Application: SSI 7485

I write regarding the proposed modification to M4-M5 Link, Mod 2 The Crescent overpass and changes to pedestrian infrastructure in North Annandale, Rozelle and Rozelle Bay Foreshore area.

Figure 4-2 Pedestrian and cyclist bridge infrastructure options

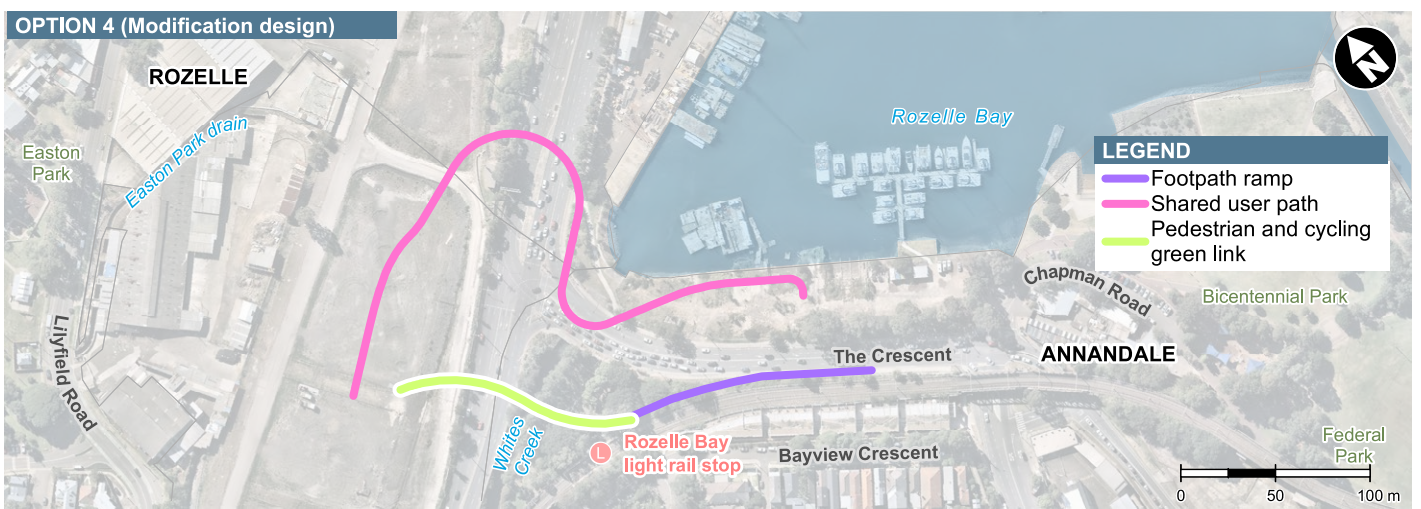
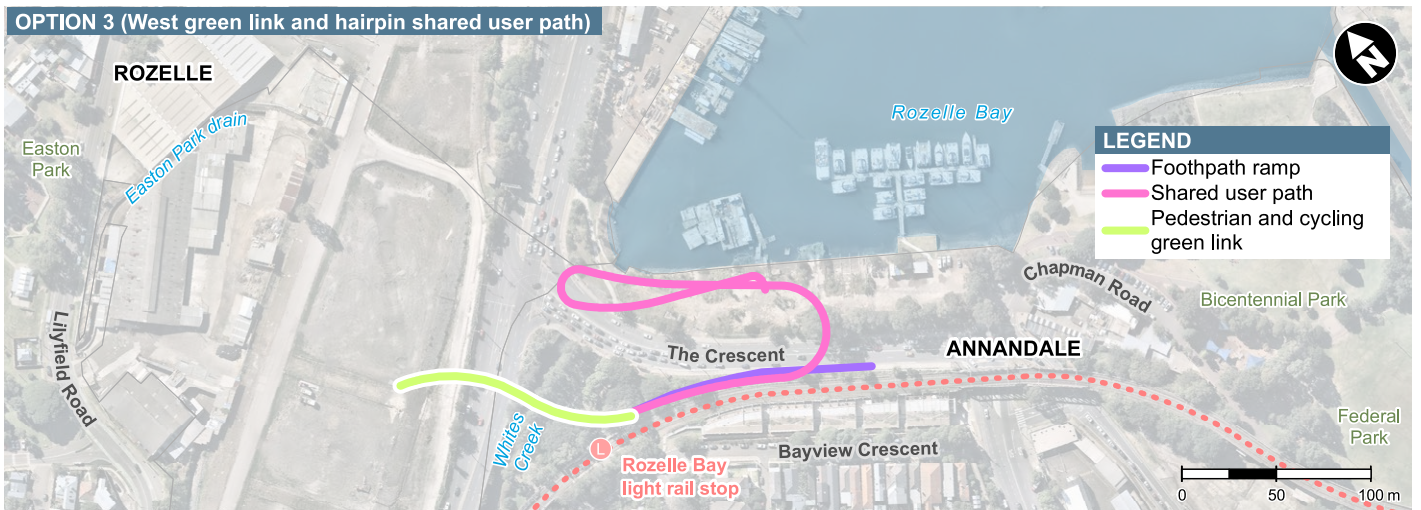
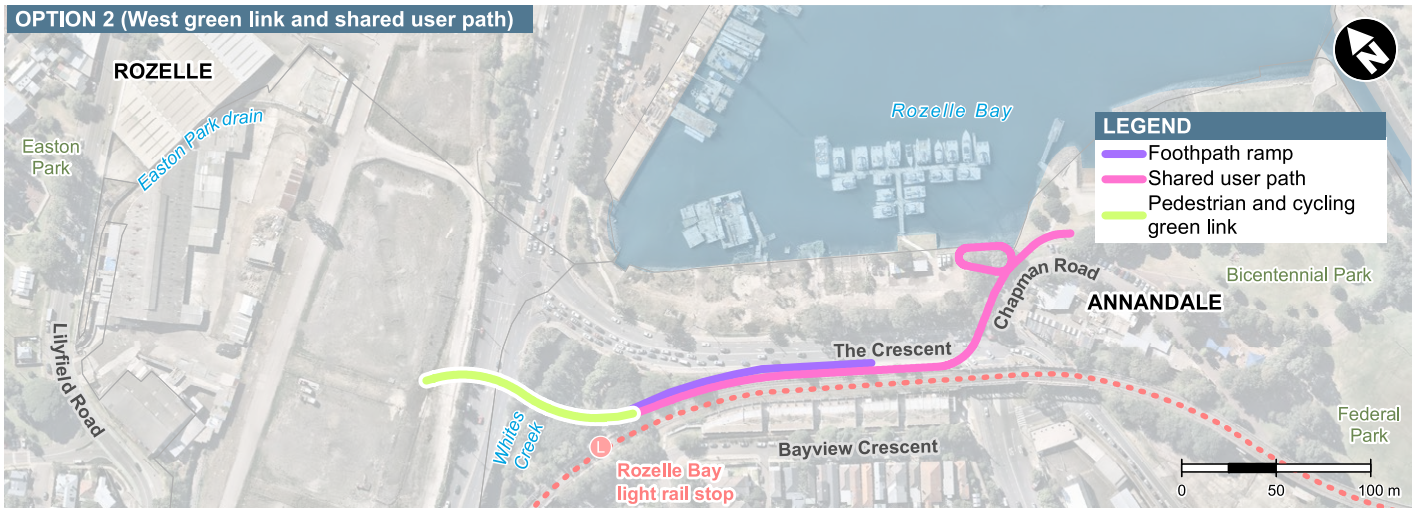
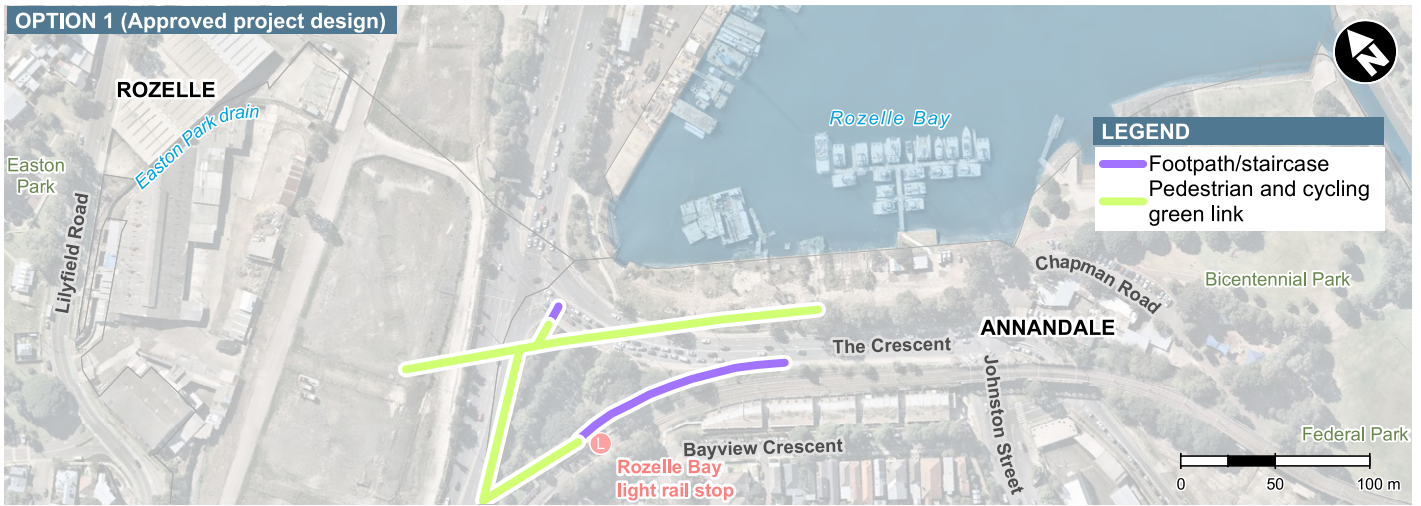
I request RMS work with the community to explore alternate design options to the proposed new car overpass design and the changed pedestrian and cyclist links. I am seeking the reinstatement of the safe, direct access from the approved EIS Greenlink to create a continuous green open space connection from the Rozelle Rail yards and Annandale to the foreshore. The Greenlink was more than just a walk way - it put people central to the design, maximising safety, and providing much needed accessible open space for the community now and into the future Bays Precinct design.

- The significantly reduced safety and increased risk for pedestrians and cyclists with removed access over The Crescent to Bicentennial Park and the increased traffic along Johnson Street.
- Being required to cross five sets of pedestrian lights at The Crescent as my option to reach the foreshore from Annandale or from Rozelle Bay light rail stop.
- Removal of direct active links to the foreshore, cutting the community off from the area and the proposed revitalisation of the entire Bays Precinct, including linking the Light Rail and Bus stops to a Ferry wharf and Metro station.
- Urban and landscape design that is being built before a finalised Masterplan for the area.
- Traffic changes that limit movements around the suburb and create further congestion in the local streets of Annandale, Forest Lodge, Glebe, Lilyfield and Rozelle with no planning to deal with these.
